Re: Required sidewalk materials Alder and Lancaster Streets - asap

I have a Level II application from the Salvation Army for an addition that will go at the corner of Preble/Lancaster/Alder. The applicant has asked for advice re replacement of the sidewalks along Alder and Lancaster (see plan below- red dotted line), since the current requirement (on the plan in the Technical Standards) is for these abutting sidewalks to be in brick.

6 BRICK SIDEWALK WITH BITUMINOUS BASE
C401 NOT TO SCALE

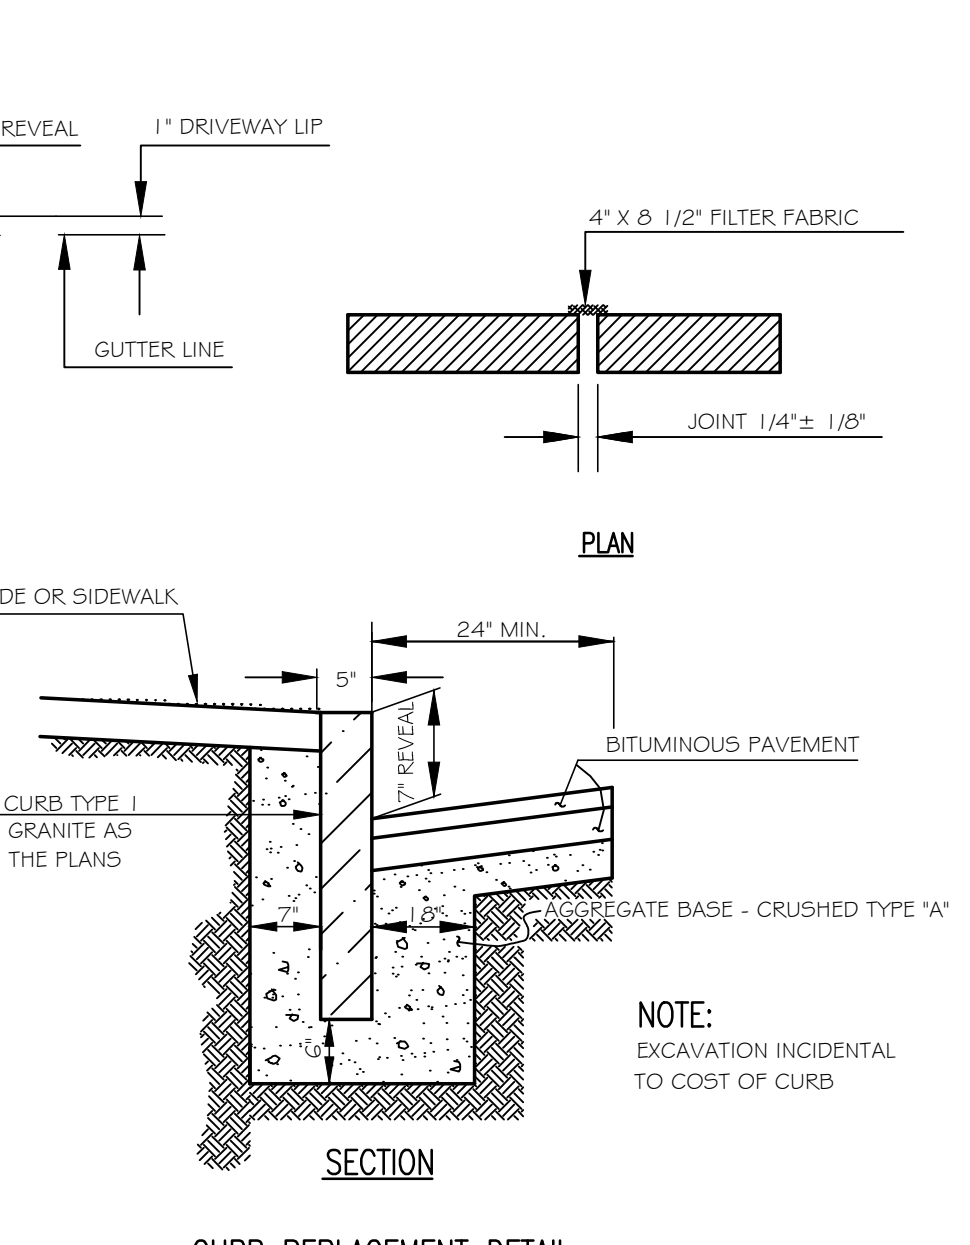
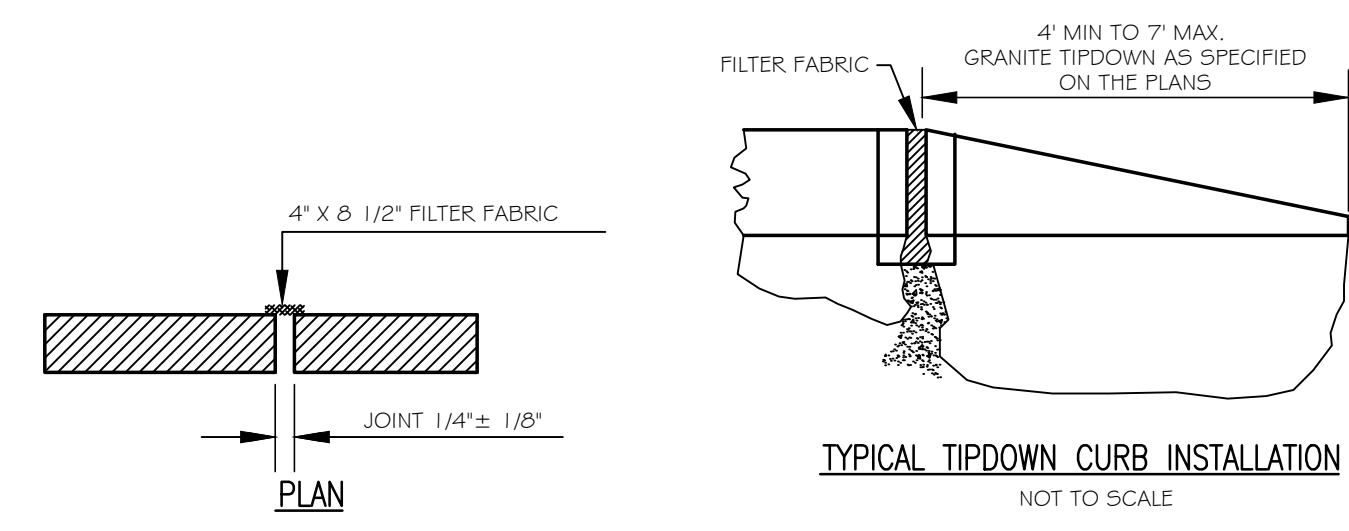
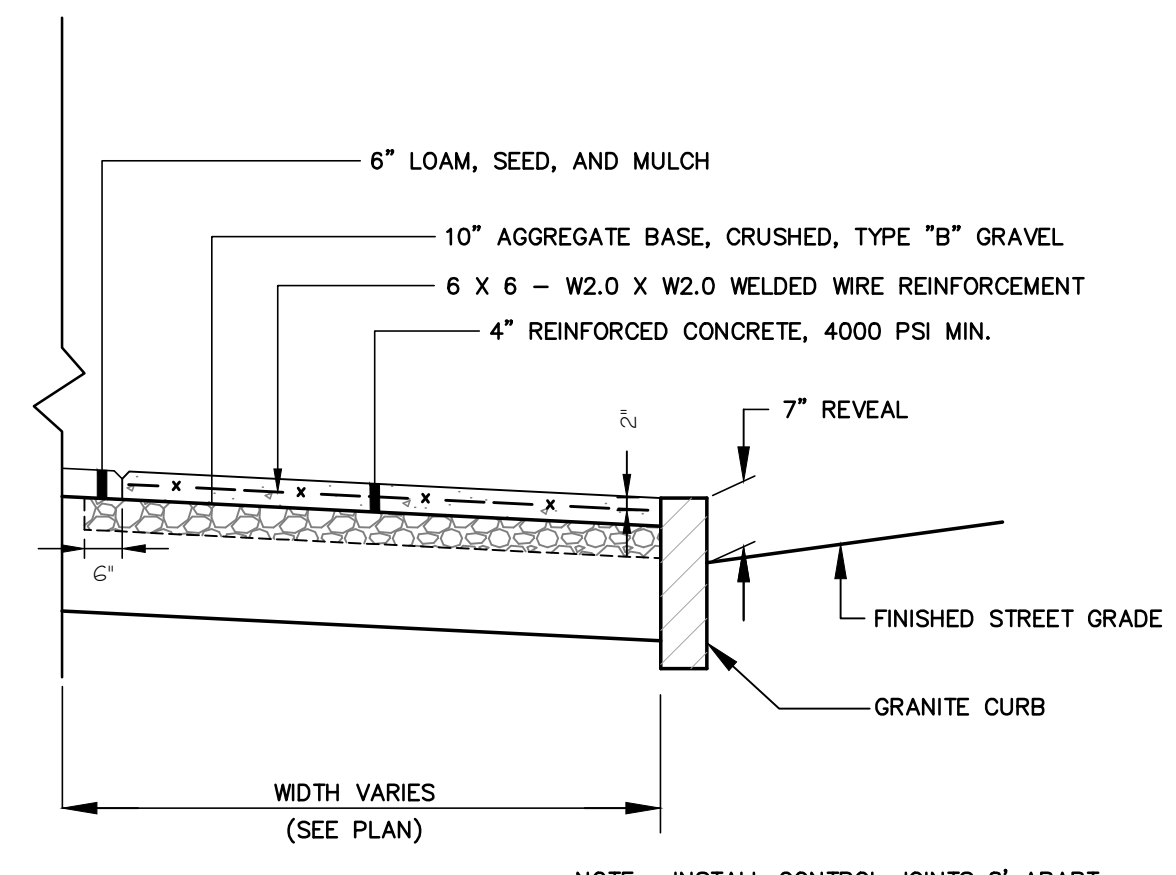
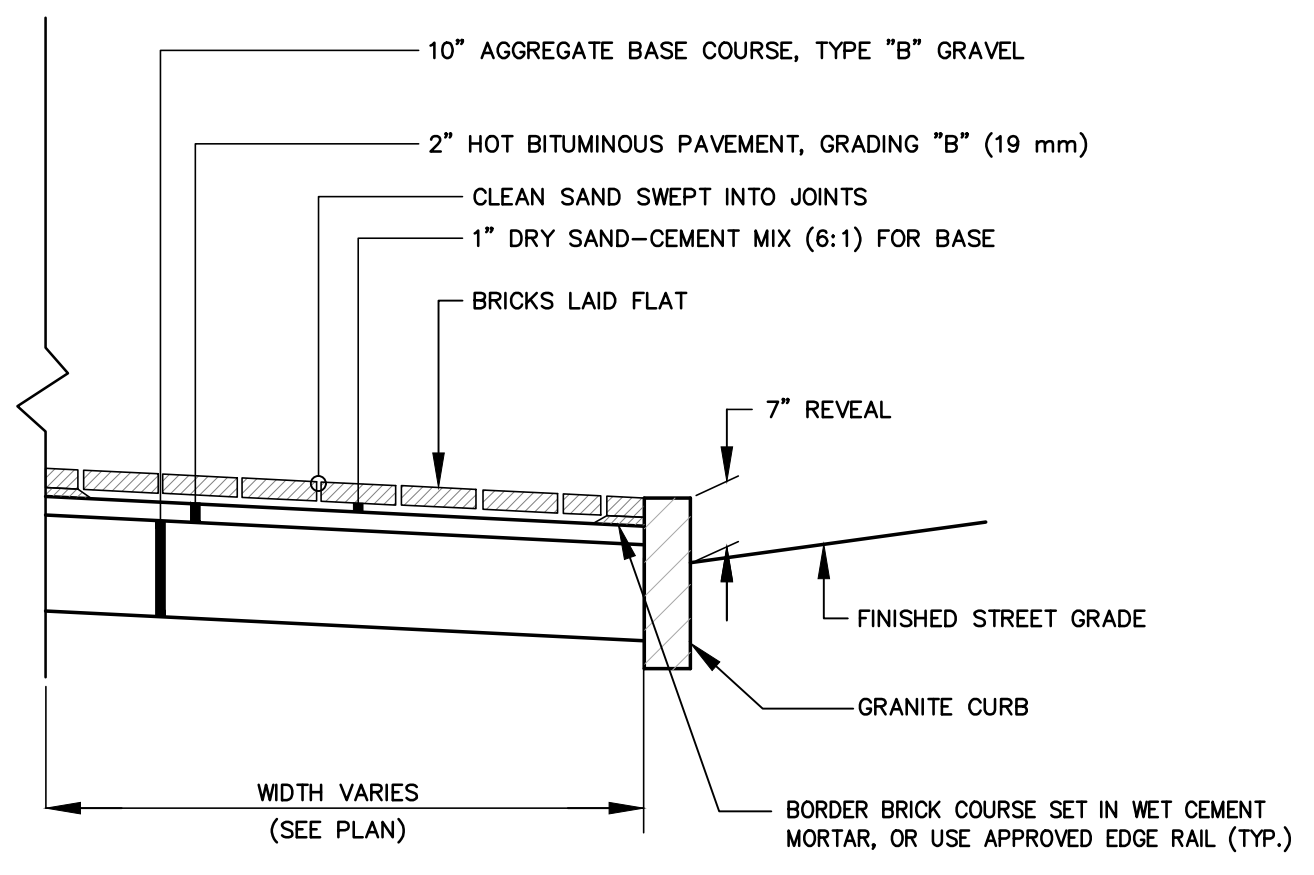
They are showing brick for both Lancaster and Alder (even though Alder has concrete in good condition and in the past DPW were more concerned about upgrading Lancaster) and as you say I am not sure they need to replace Alder with brick.

We took some time after our review session today (thanks Barbara & Lauren for staying late!) to review the newest plans. As stated previously, we must hold the brick policy for Lancaster (& Preble) at this time. If and when the City changes the material policy for Lancaster before they actually construct the sidewalk, we can make a field amendment.

As for Alder St.; based on the one lateral and two driveway alterations presented on the plans, the majority of existing concrete sidewalk being in good condition, and their site work not exceeding 50% of the block length - DPW can support replacing disturbed sidewalk area with concrete in accordance with our 'repair' strategy practice. The driveway aprons will have to be constructed of asphalt however per the driveway apron material policy embedded in the Sidewalk Material Policy.

DRAWN BY  
SHEET TITLE **Site Layout and Utility Plan**

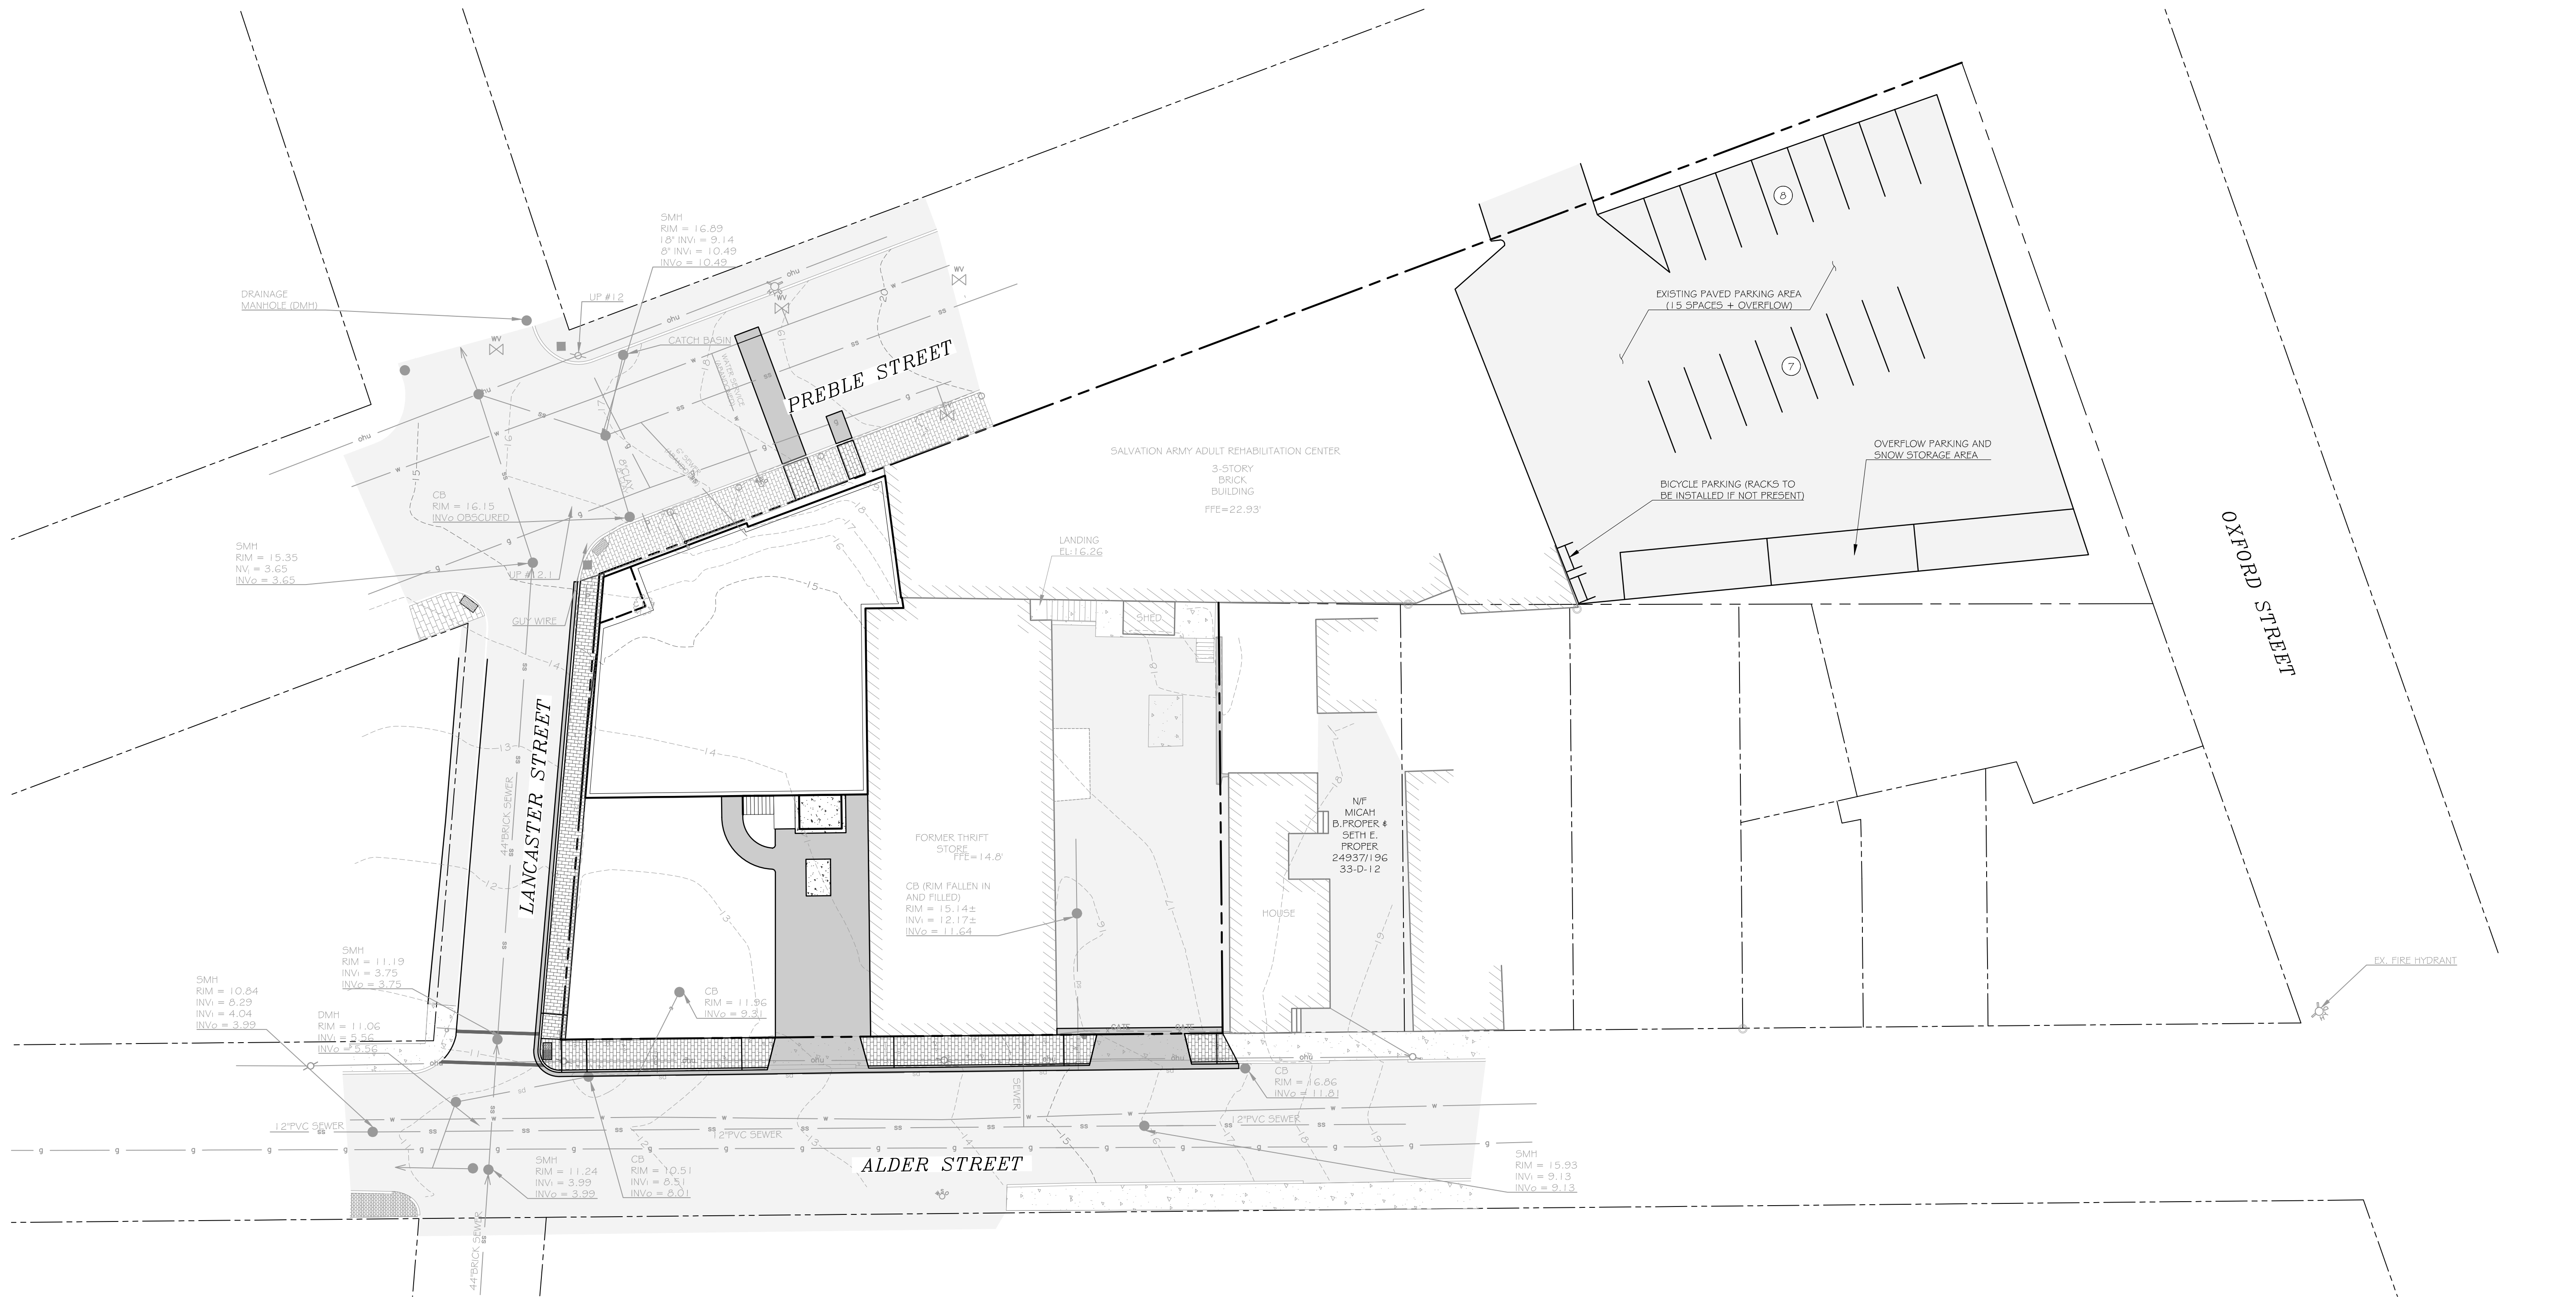
Alder is currently concrete (in good condition but they need to take one utility through it) and Lancaster is asphalt (Preble is already brick in good condition). The logical and most cost effective solution would be to have them replace Lancaster with concrete. (They will replace with brick if that is the requirement but I am not sure we can require them to replace the good condition concrete in Alder with brick)
